Current Zoning: N1-A (neighborhood 1-A)  
Proposed Zoning: INST(CD) (institutional, conditional)

Approximately 14.46 located along the southeast side of Carmel Road, west of Colony Road, and east of Mooreland Farms Road.

The petition proposes to allow the renovation and expansion of an existing assisted living/independent living senior facility.

# RZ-2

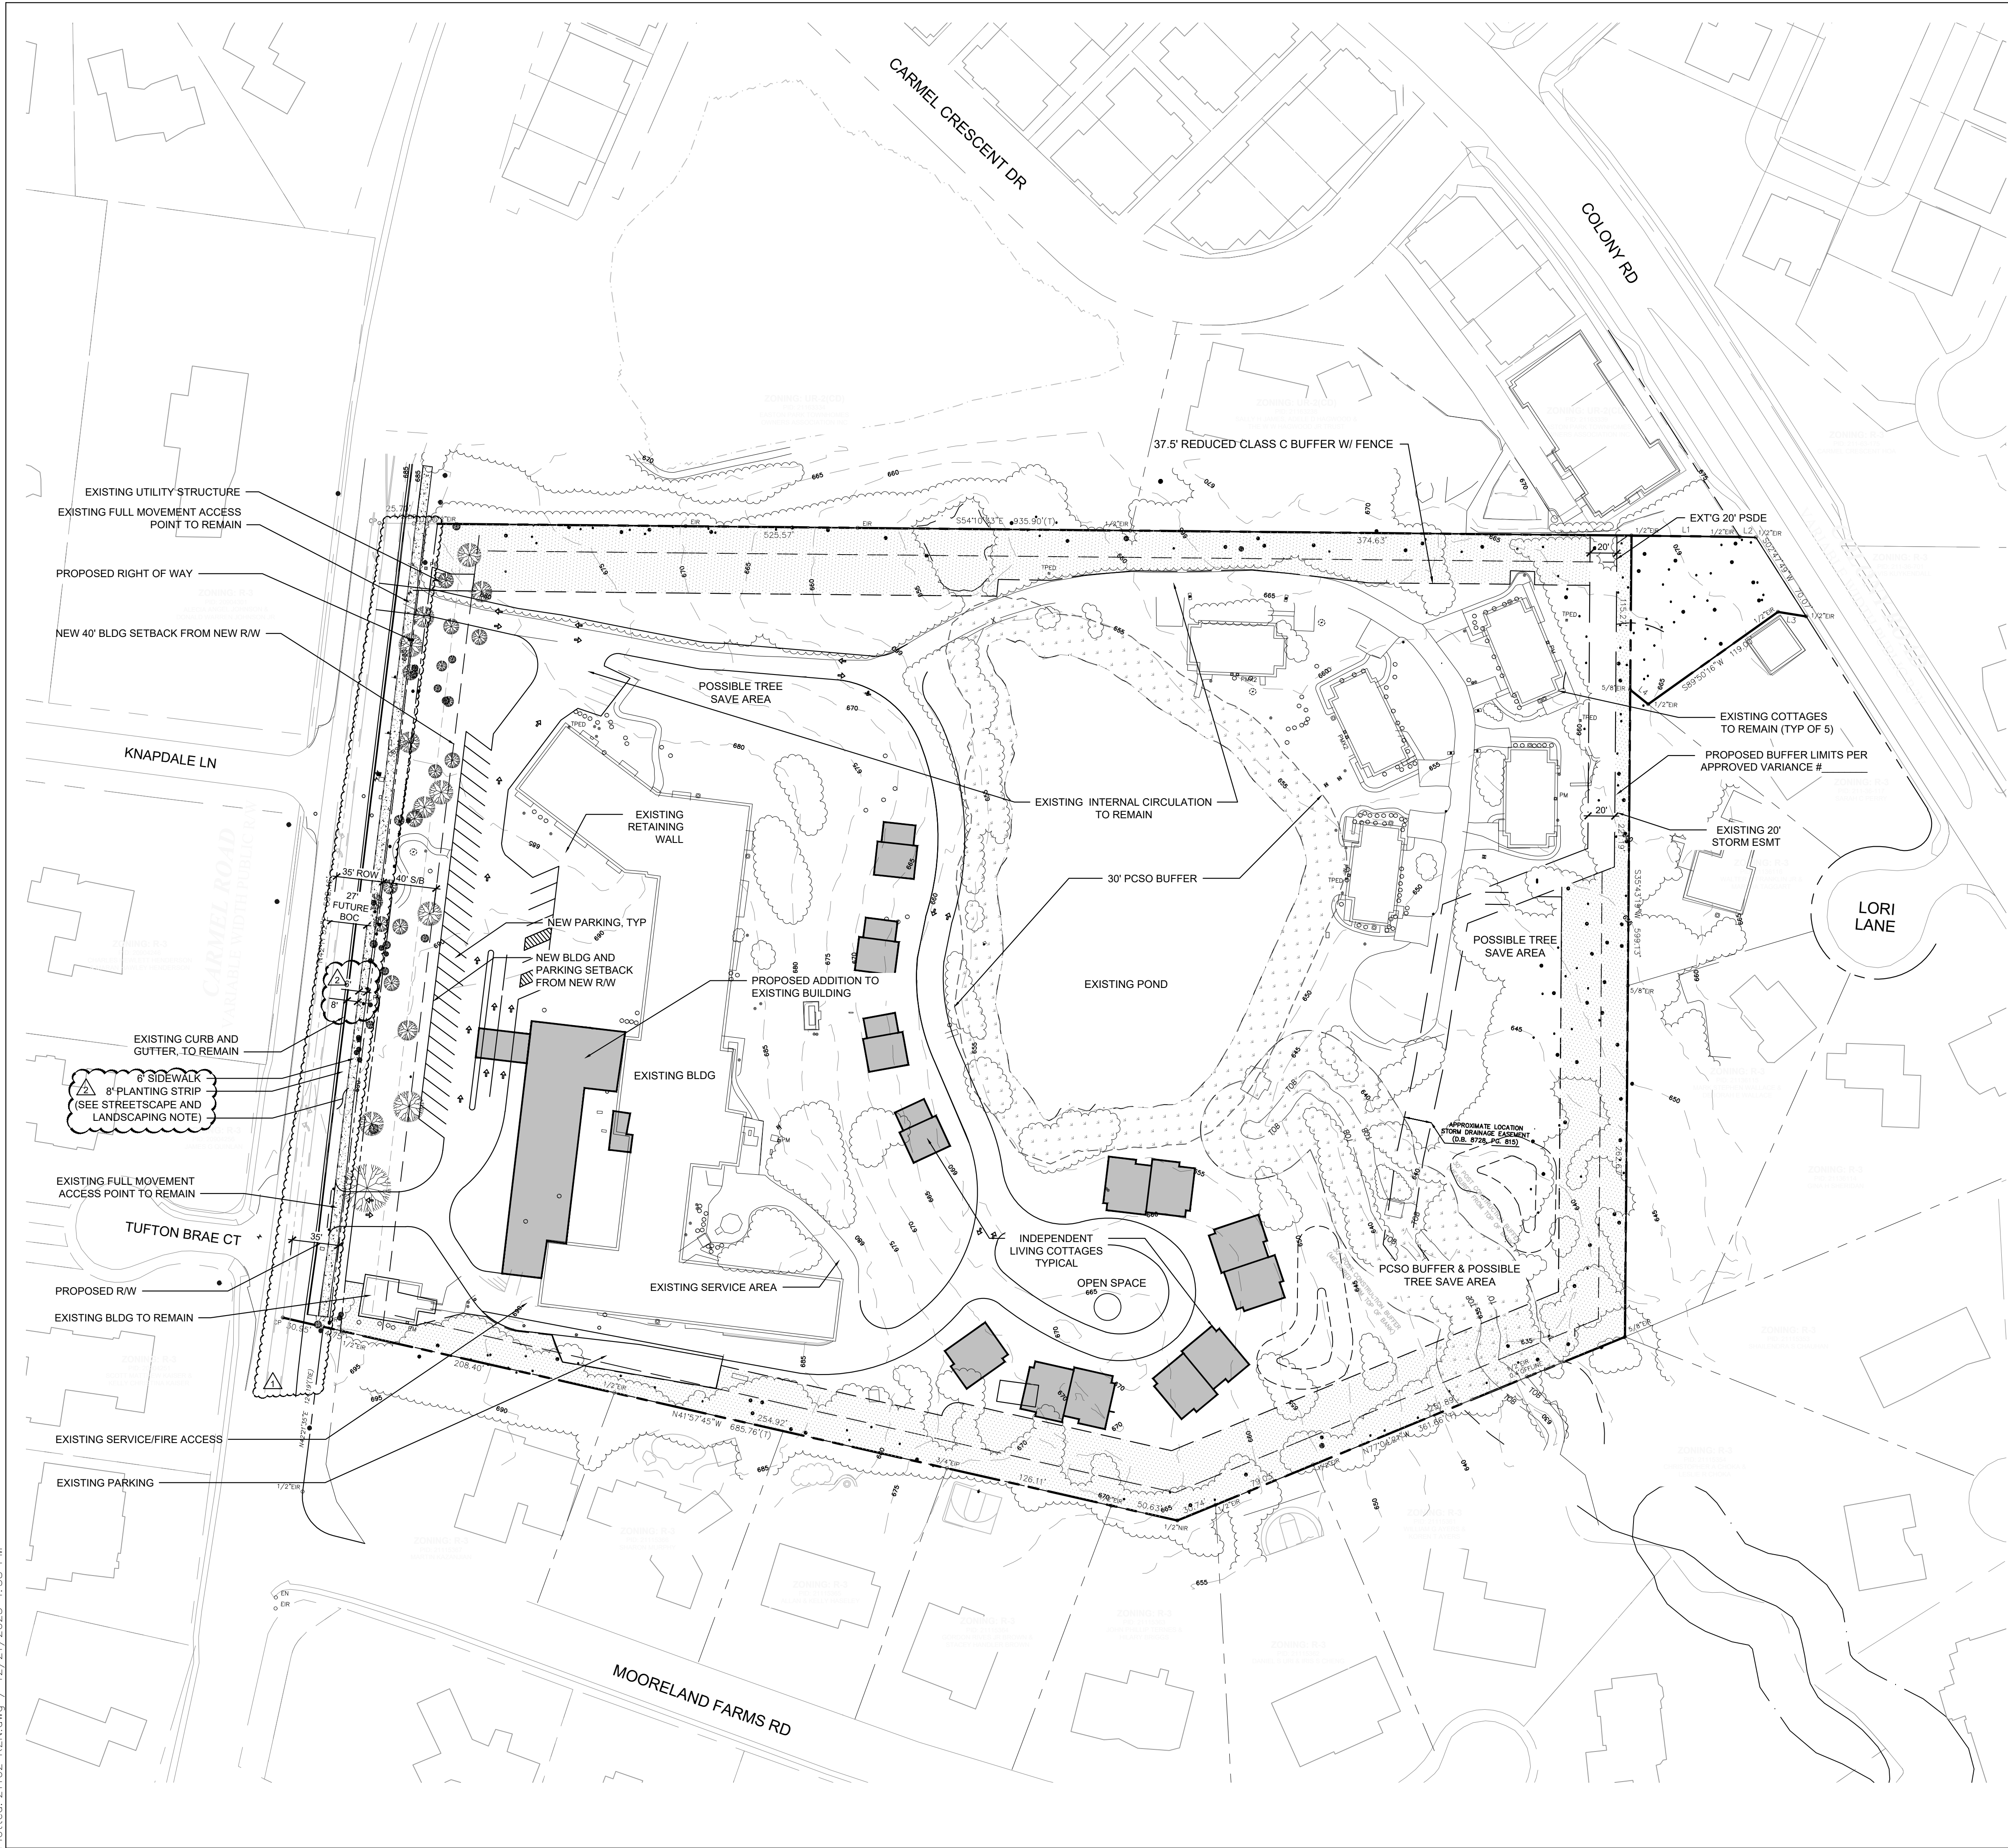
- ~~1. Colony Road: Location of future curb and gutter to be moved to 24 feet from roadway centerline to accommodate the Charlotte Streets Map with a roadway typical section of CLDSM 11.09 Minor Thoroughfare. Per Chapter 19 revise site plan and conditional note(s) to commit to construct an 8-foot planting strip, and 6-foot sidewalk on Carmel Road and Colony Road.~~ **ADDRESSED**

- ~~2. Revise site plan and conditional note(s) to commit to dedicate 43 feet of right of way from the Carmel road centerline and 40 feet of right of way from the Colony Road centerline. The site plan shall label and dimension the right of way from the road centerline.~~ **ADDRESSED**

- ~~3. Request to revise site plan and conditional note(s) to commit to construct a buffered bicycle facility along Carmel Road by locating the back of curb and gutter 27' from the center line to meet the Council-adopted Charlotte BIKES Policy.~~ **ADDRESSED**

- ~~4. Add a conditional note specifying "All transportation improvements will be approved and constructed before the site's first building certificate of occupancy is issued. The petitioner may phase transportation improvements if said improvements and phasing are explicitly described in site plan notes."~~ **ADDRESSED**
